Your Ref: **32111000**
Our Ref: **G pre00220/2019**
(Please quote in all related correspondence)

06 July 2020

Re: Scoping Document for proposed replacement of 7 manned level crossings between Limerick Junction and Cork City on the Dublin-Cork Railway line.

| Project | Cork Line Level Crossing Project | Drawing | Interpretation M1 XC211 (Newtown Townland), Co. Cork | | |

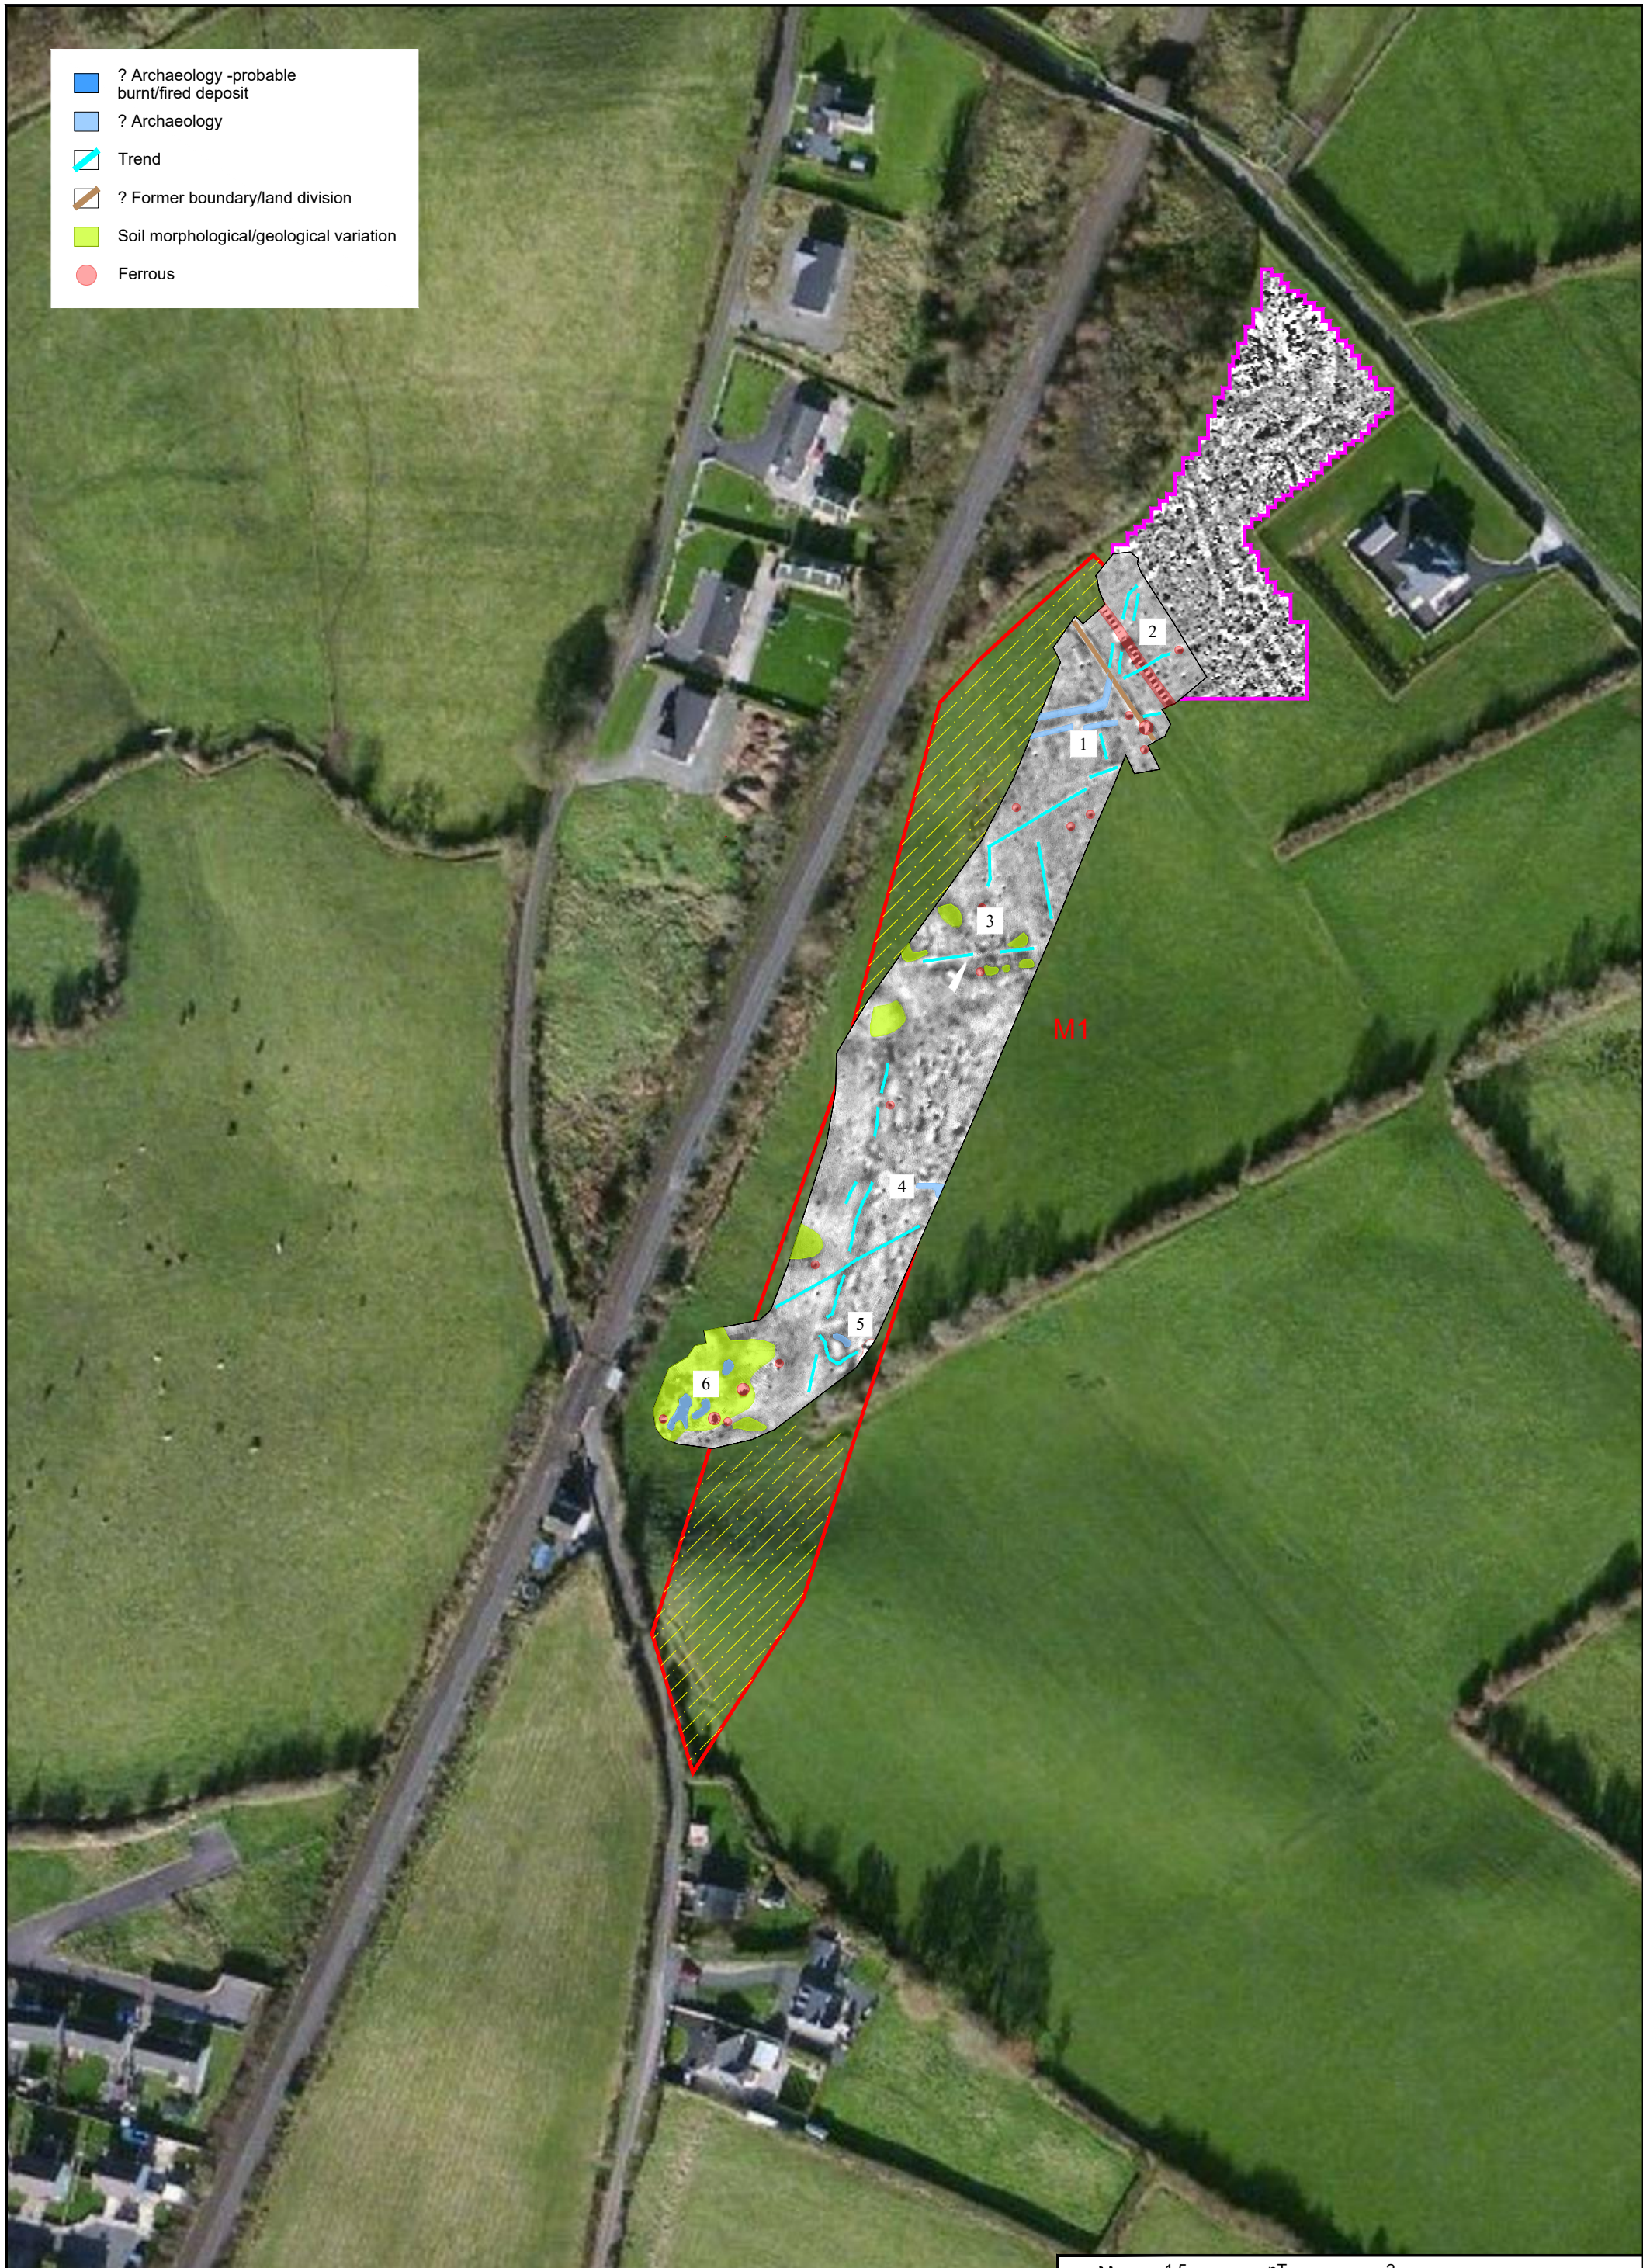
As noted in the report 20R0017 Newtown a number of subsurface anomalies were recorded in the vicinity of Recorded Monument CO008-040--- *Ringfort*. These anomalies may represent archaeological features/deposits associated with this monument. Archaeological mitigation in this regard is now outlined below.

2. A programme of targeted archaeological test excavation, based on the results of the geophysical survey, is required at Newtown, Co. Cork in order to establish the location, nature and extent of archaeological features/deposits recorded.
